I write to submit my comments regarding planning applications 2021/1089 & 2021/1090.

HOUSE TYPE CODE: MY 02-V6-5 (NAPLES)			Strata Homes Limited, quay point, lakeside, Doncaster, DN4 5PL	
Title:	PLANNING AS - BRICK ELEVATIONS	SCALE @A3 - 1 : 100		
187-SQ M	Drawn:	LM		
2009-SQ FT	Checked:	LA		
	Dwg No:	101		
			www.stratahomes.co.uk T 01302 308508 F 01302 308501

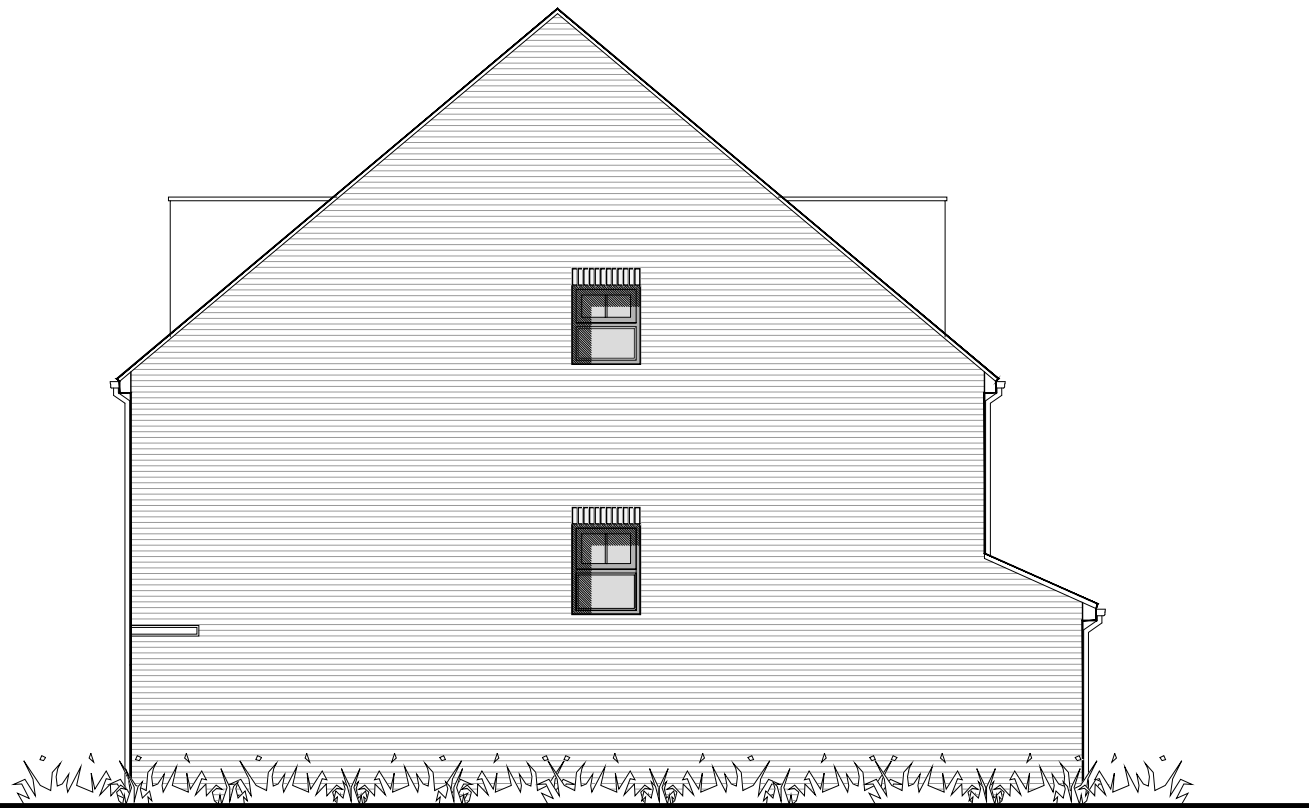
A significant concern for residents of Higham is privacy. I do not believe the plan in its current state mitigates privacy issues. My colleague Cllr Chris Wray has been vocal on this issue and received assurances which seem to have been broken. Councillors and BMBC were assured that no three-story houses would be backing up to the bungalows on the western side. As specifically seen in the Phase One residential development plan, this is still false.

Semantics could be used that these are “2.5 stories”, but the harsh reality is that this is a third story, and houses, as seen in the residential plot, meet this. Specifically, these are houses 117, 118, 119, 185, 189, 190, 196, 197 and 200. My residents want their privacy respected, and this plan blatantly opposes that.

4.12 LINK ROAD

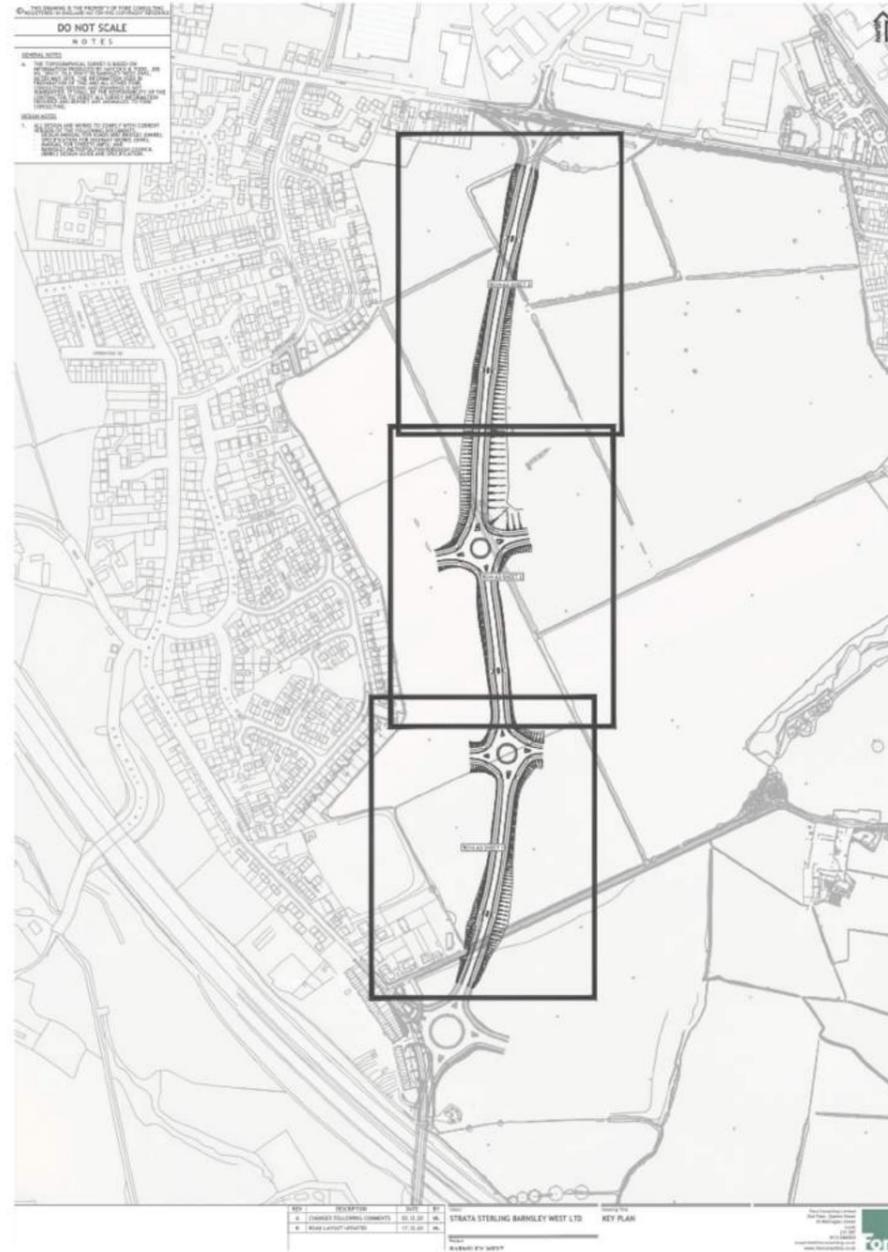
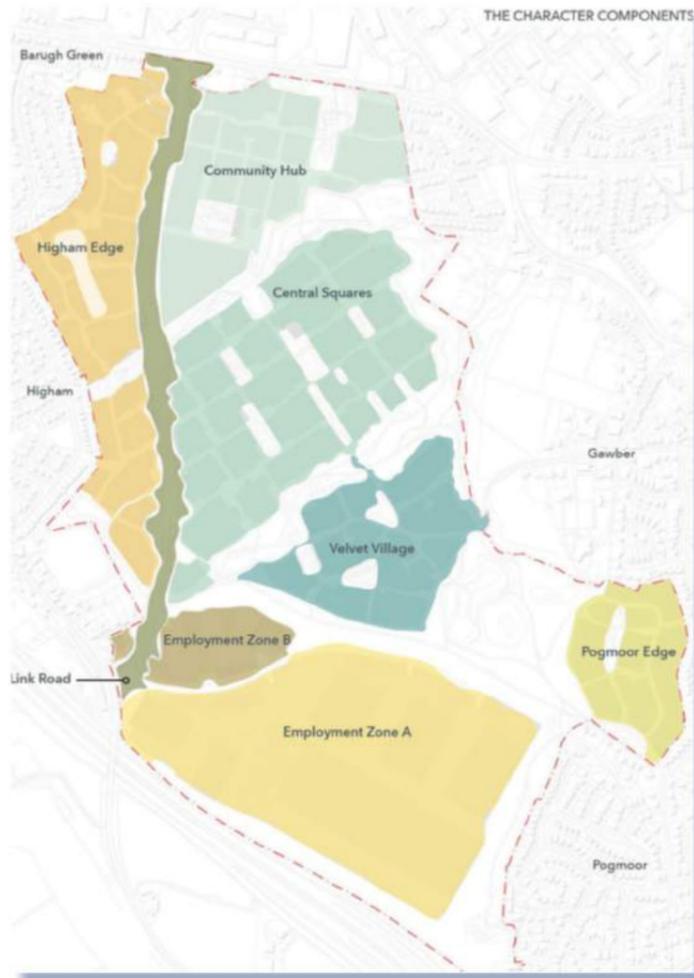
As such, the link road should most certainly be developed first to enable access via both the site's top and bottom and avoid the certainty of an incident occurring. It is also concerning that Strata have included the link road, affordable housing and “open space” to discuss around S106 money. The link road is essential for the development, affordable housing is currently at its bare minimum planned, and the open space is actively being removed from residents.

The traffic assessment lacks evidence to support the rosy claims of almost no negligible impact. Beyond that, the idea that the link road is still ethereal at best is a serious failing. This link road must be developed first for the safety of surrounding residents and the correct traffic flow around the wider area.
